Our Ref: EN010085

Date: 14 December 2018

### **Application by Cleve Hill Solar Park Ltd for an Order Granting Development Consent for the Cleve Hill Solar Park**

#### **Advice Following the Issue of Decision to Accept the Application for Examination**

Project Title

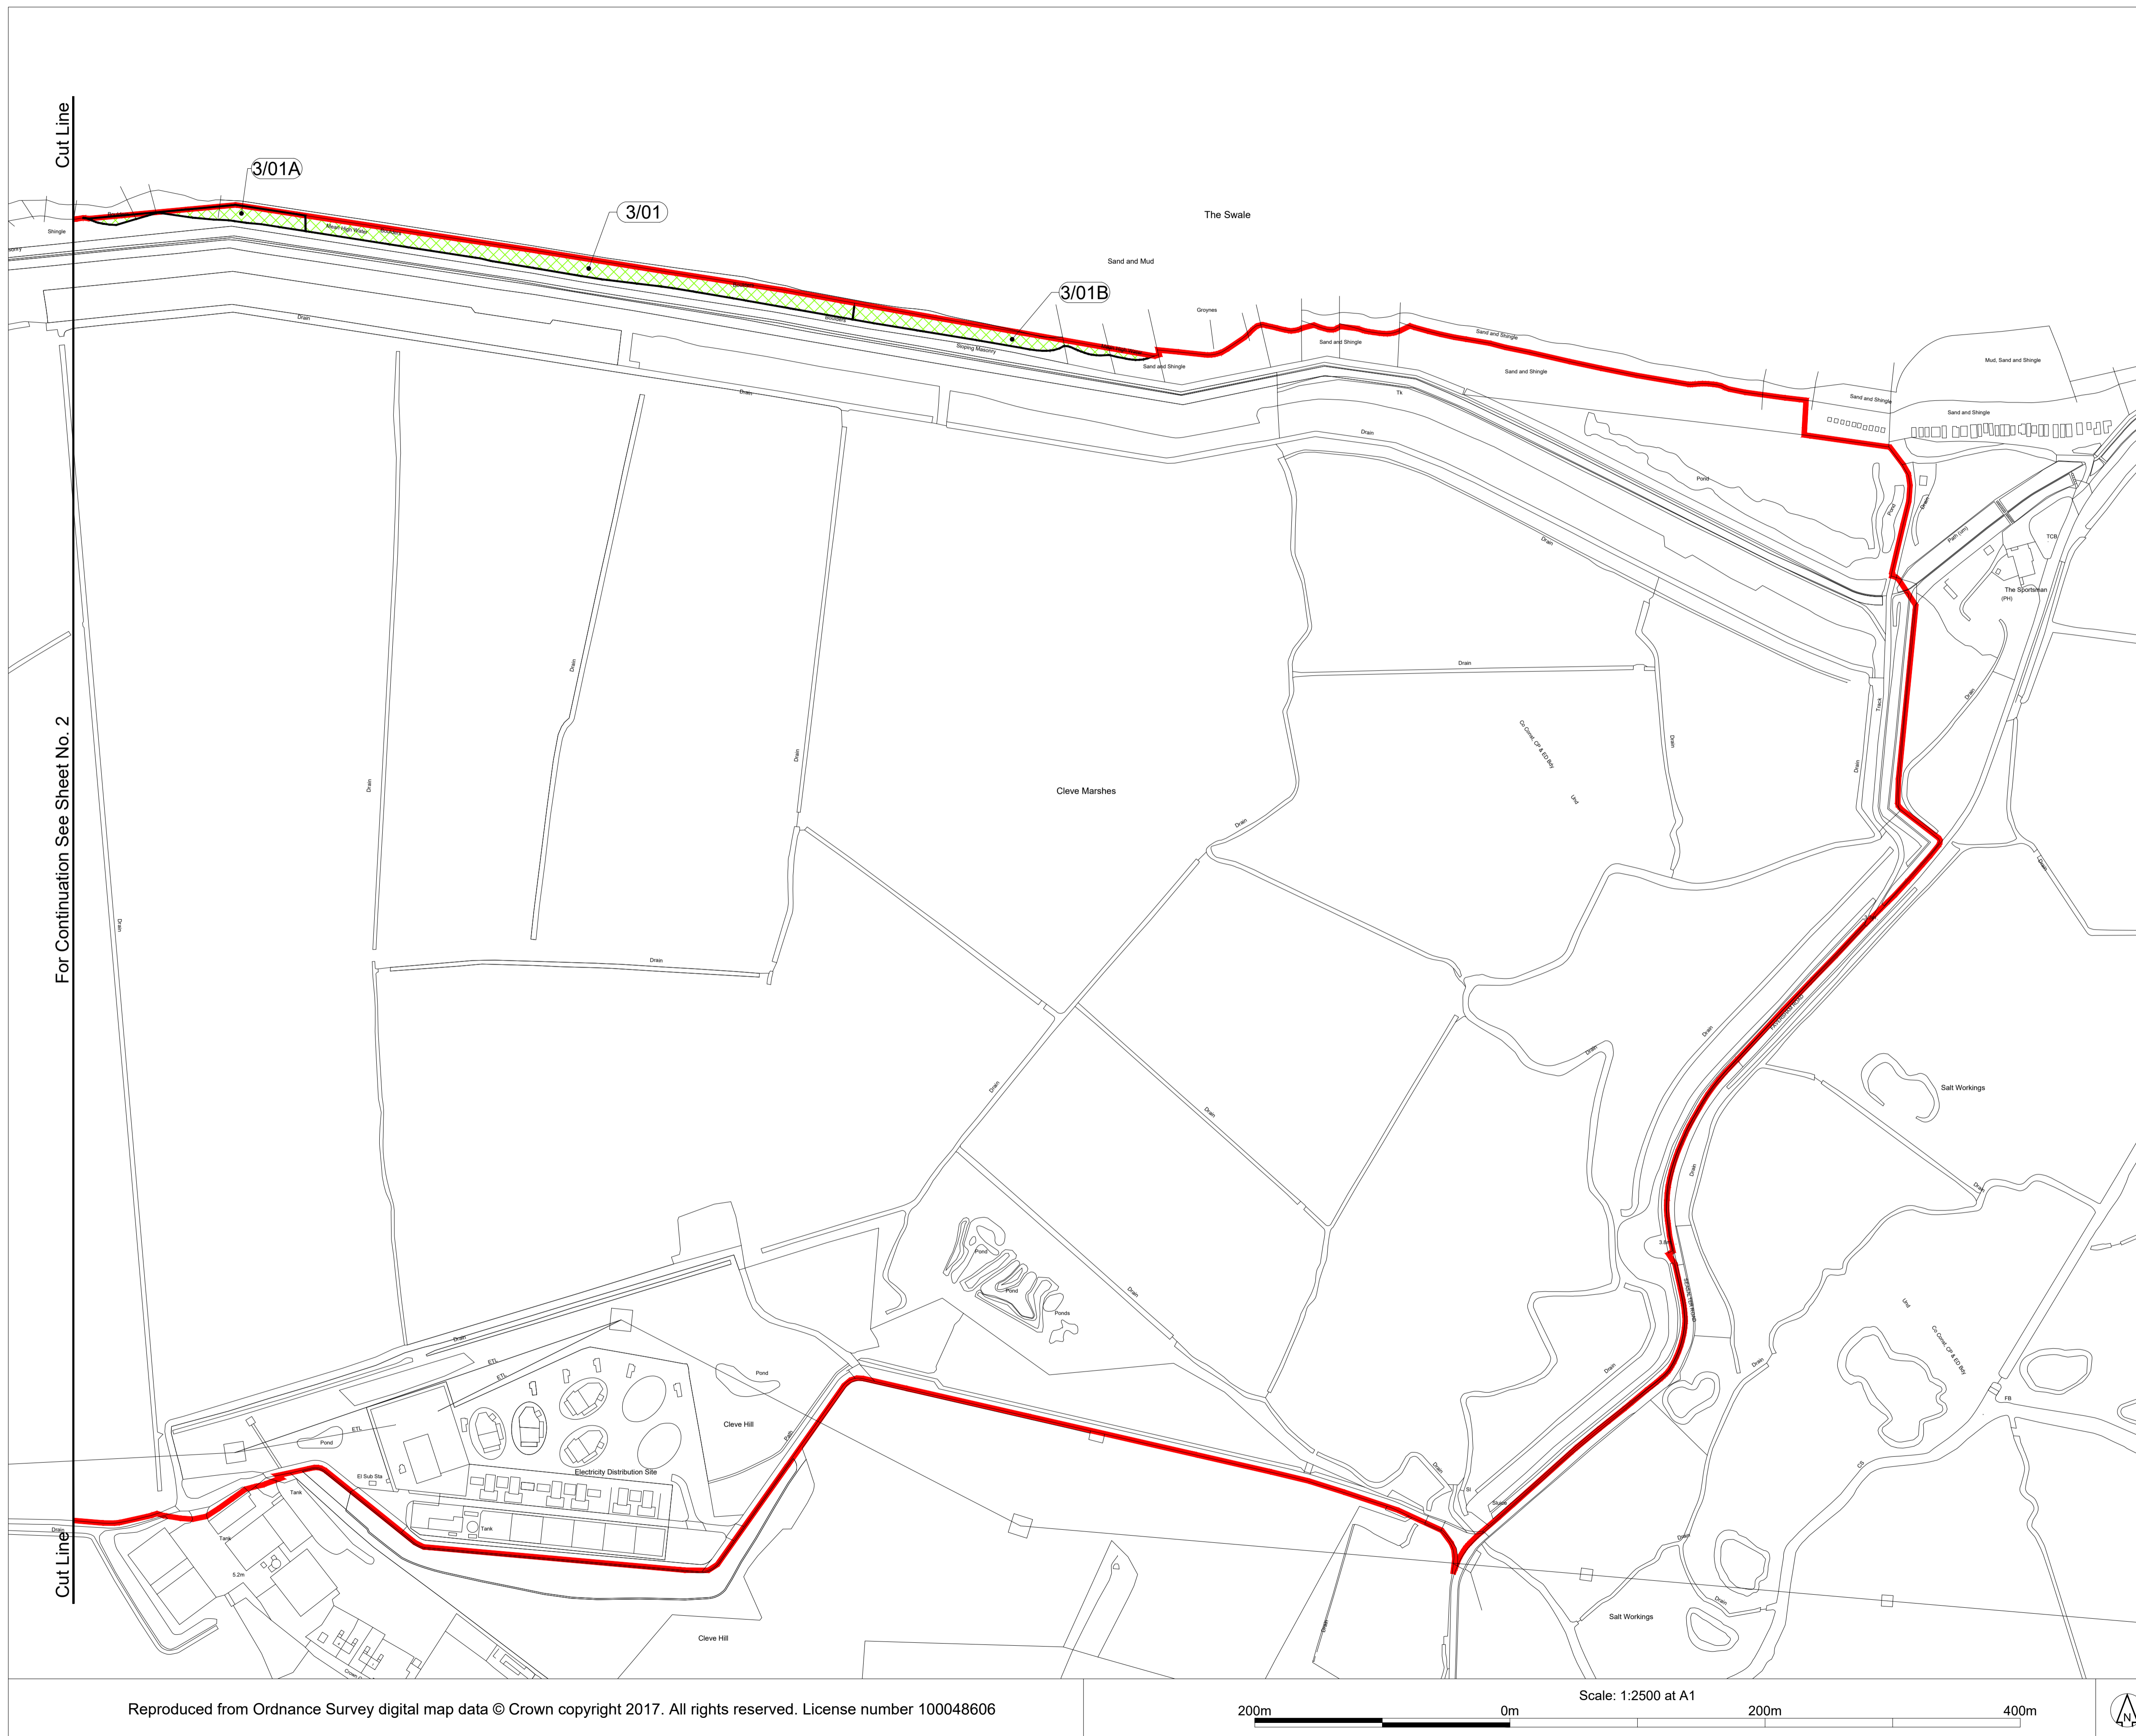
The Inspectorate has noted that the inset sections detailing the smaller plots (used on the land plans (**Doc Ref 2.1**)) are missing from the Crown Land plans. This can make seeing the affected plot difficult without also viewing the land plans. Please can the Applicant provide clarity on this.
